CITY OF ALBUQUERQUE

**Re: Boulders Phase II
 Release of Financial Guarantee—Not Accepted,
 Stamp Dated 11/19/2013
 Engineer's Stamp Date 10/24/2012 (B11/D001C)**

DRAWN BY  
DY  
DATE  
9-06-12  
DRAWING  
OVERALL GRADING  
SHEET #  
**3**  
JOB #  
2011005

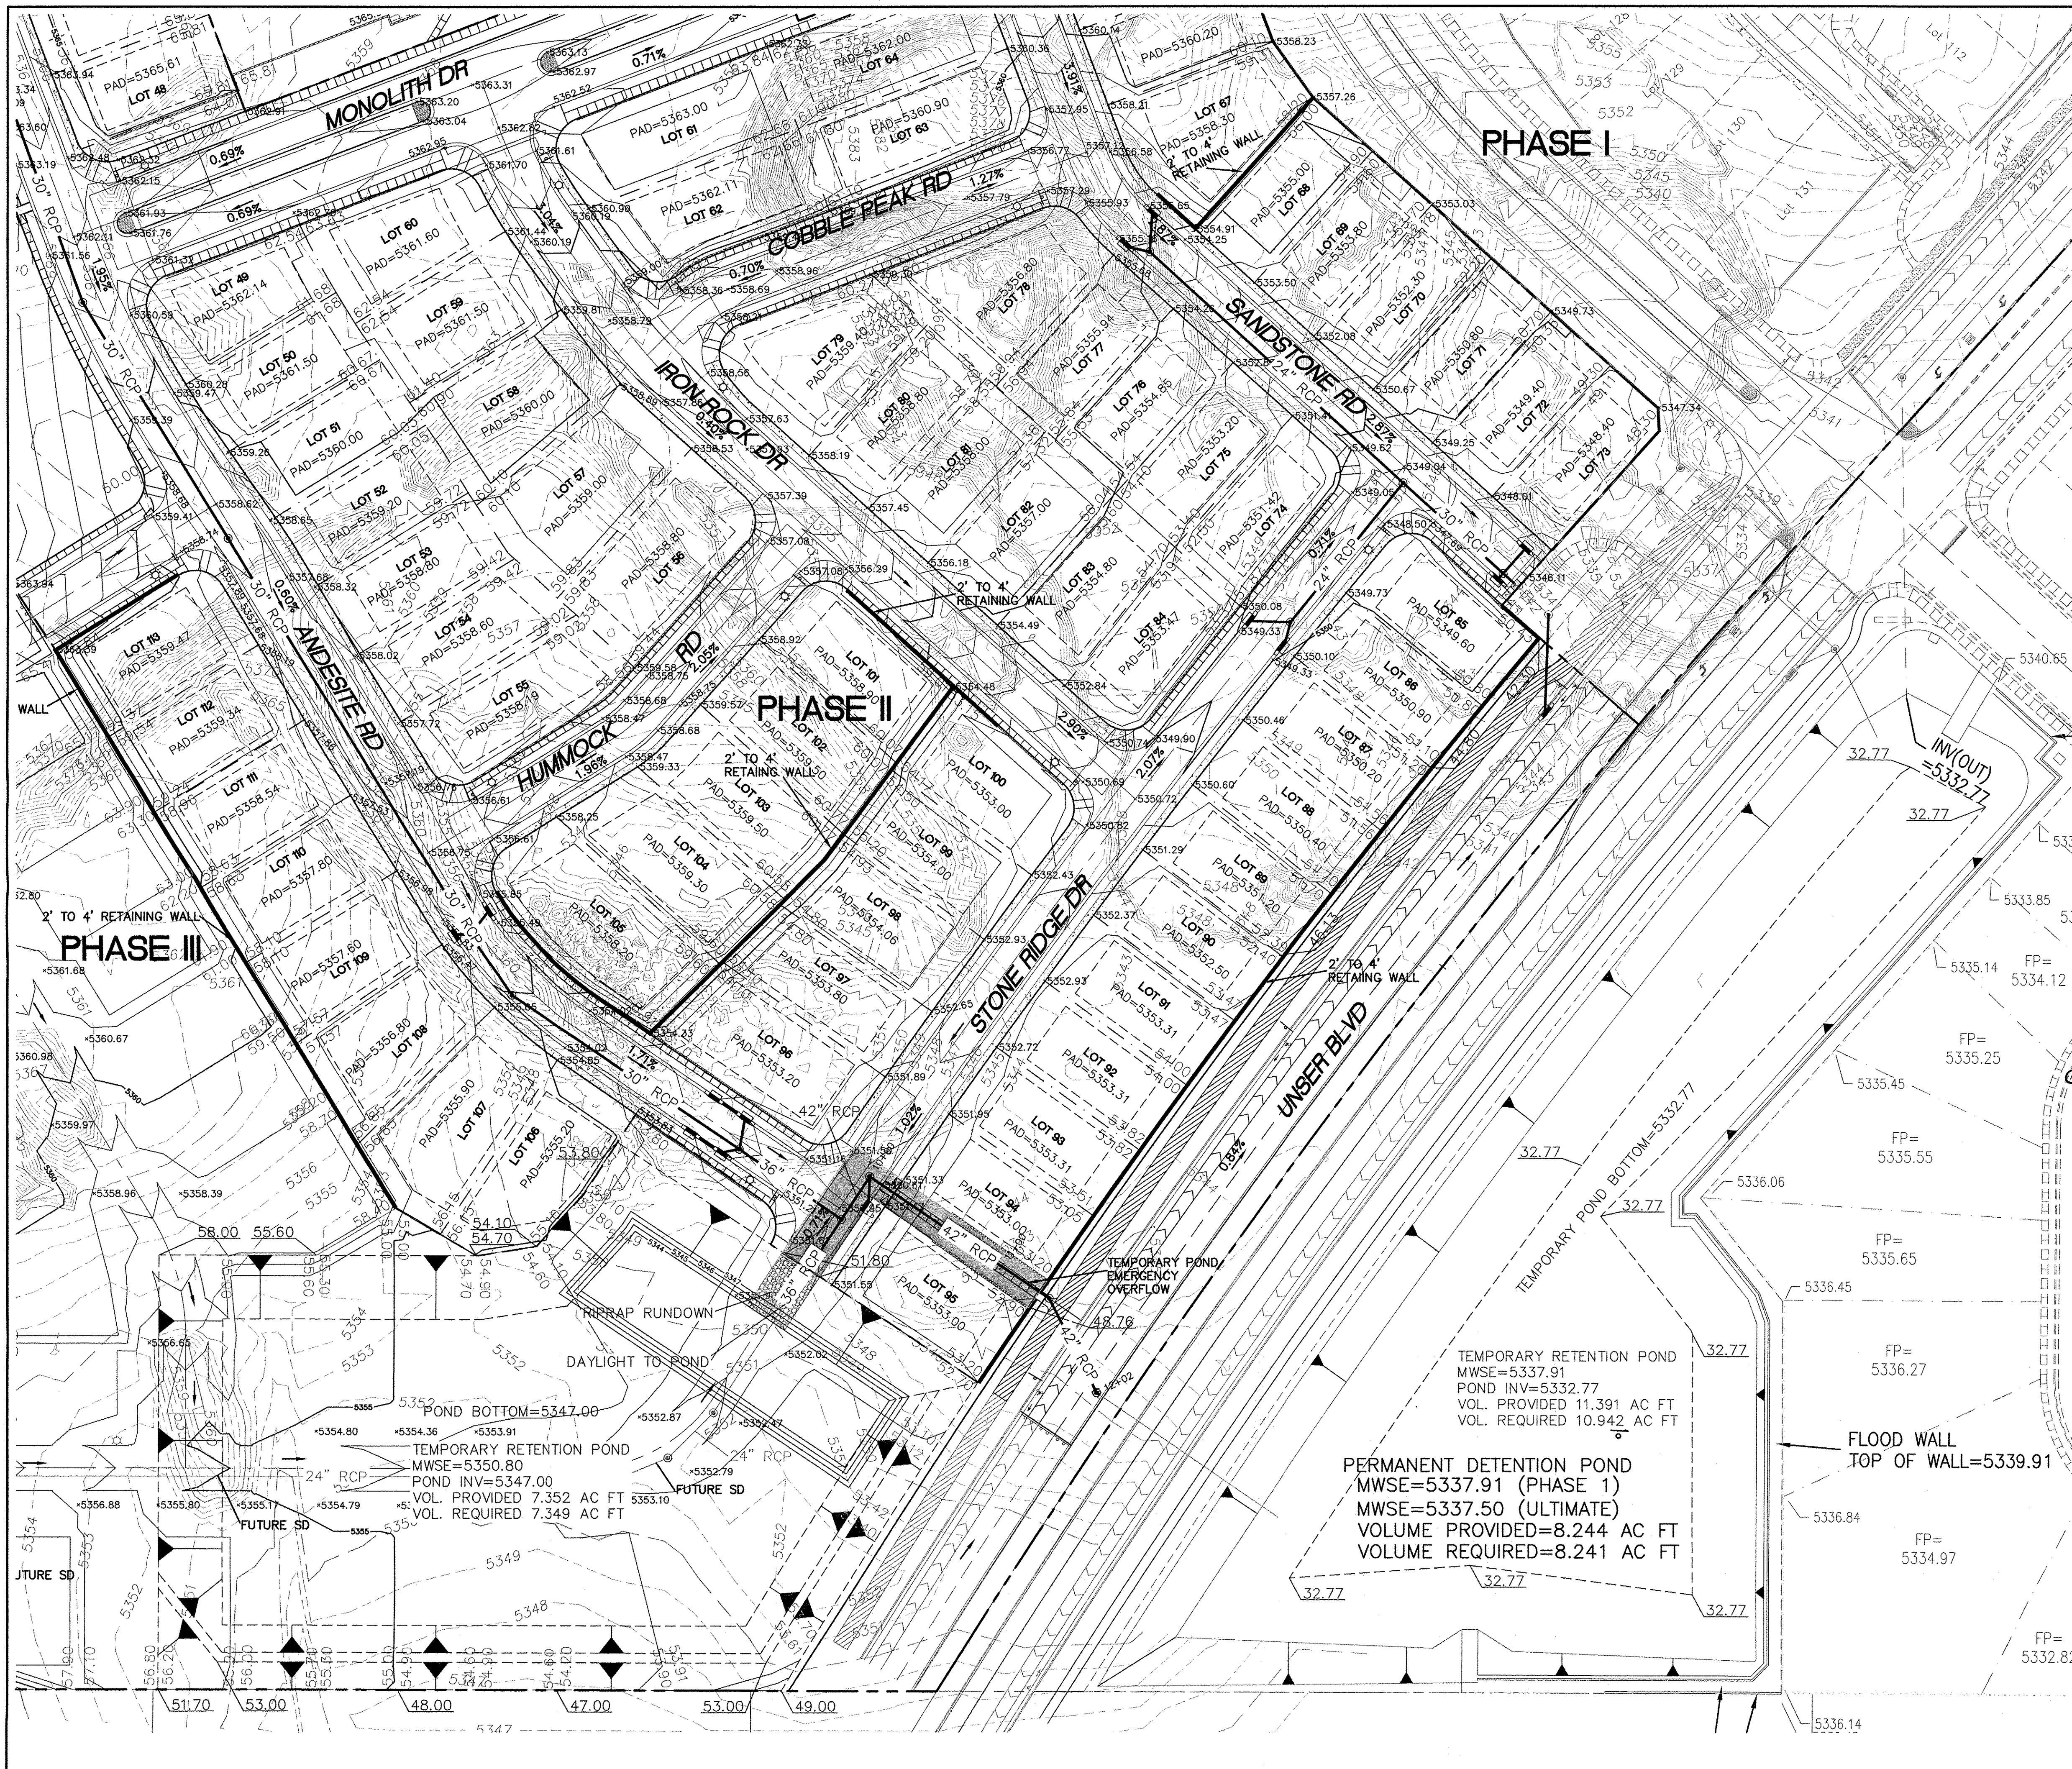
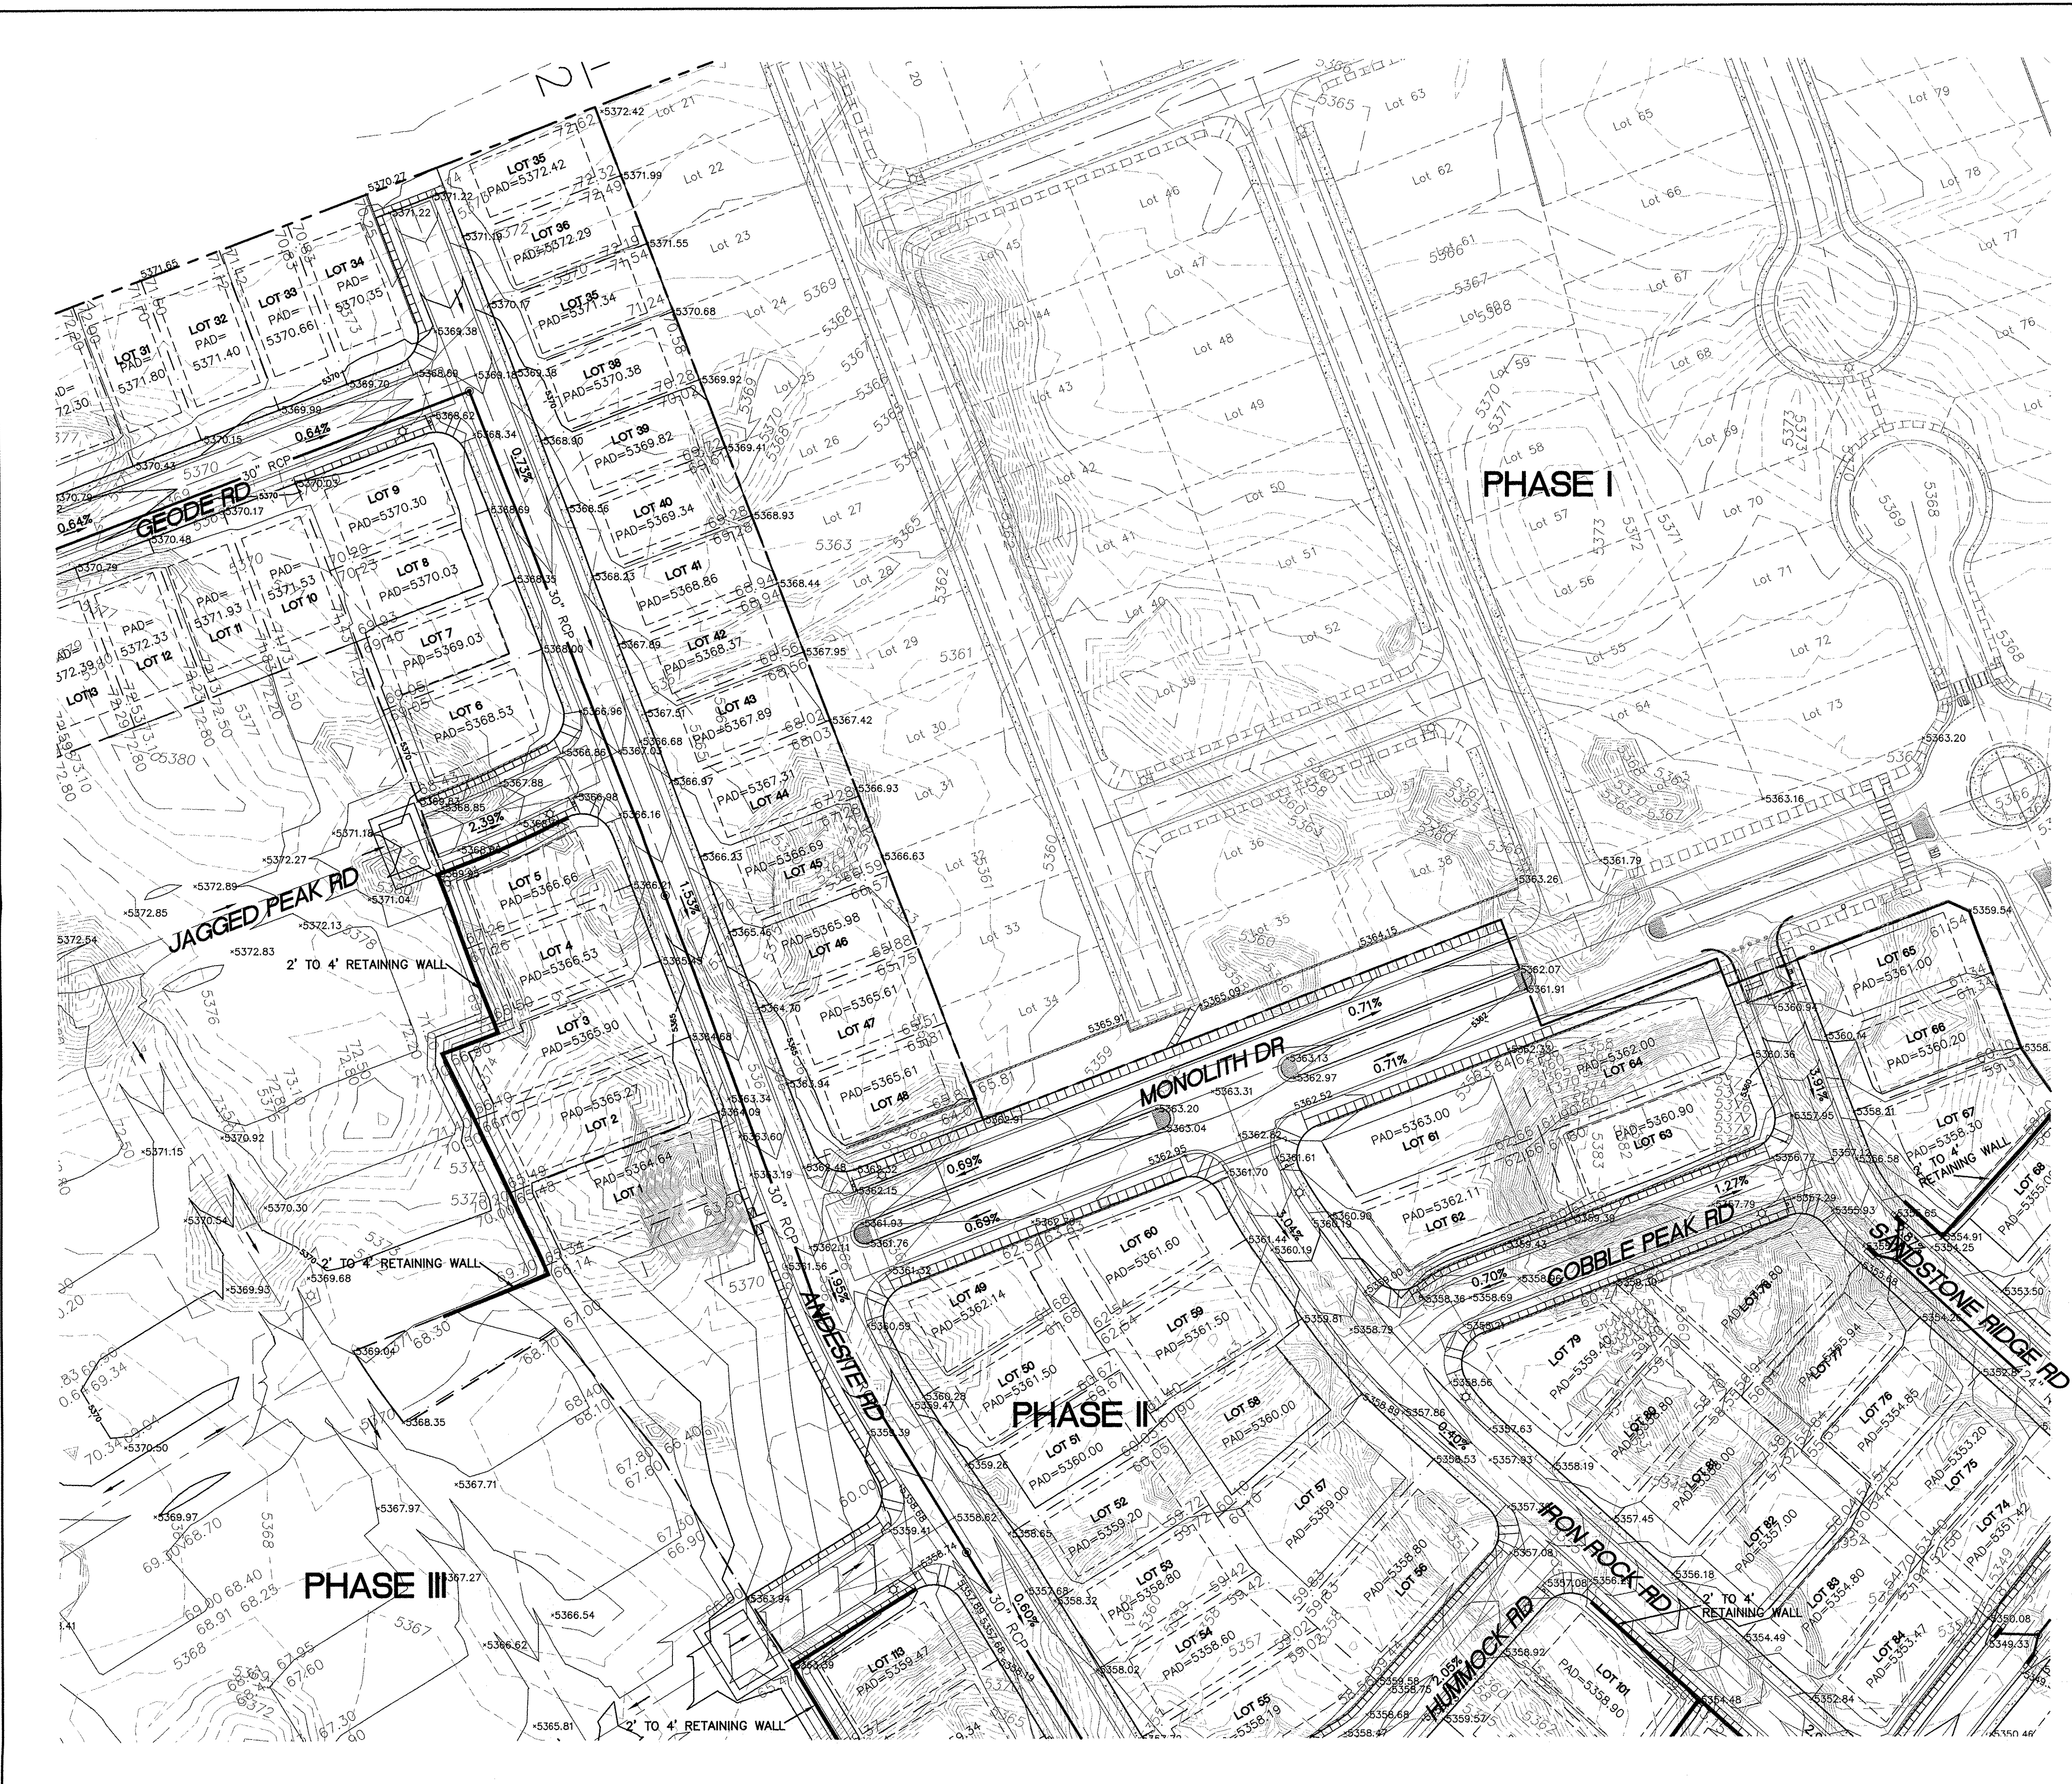
Please provide the pad grades on the DRB approved grading and drainage plan.
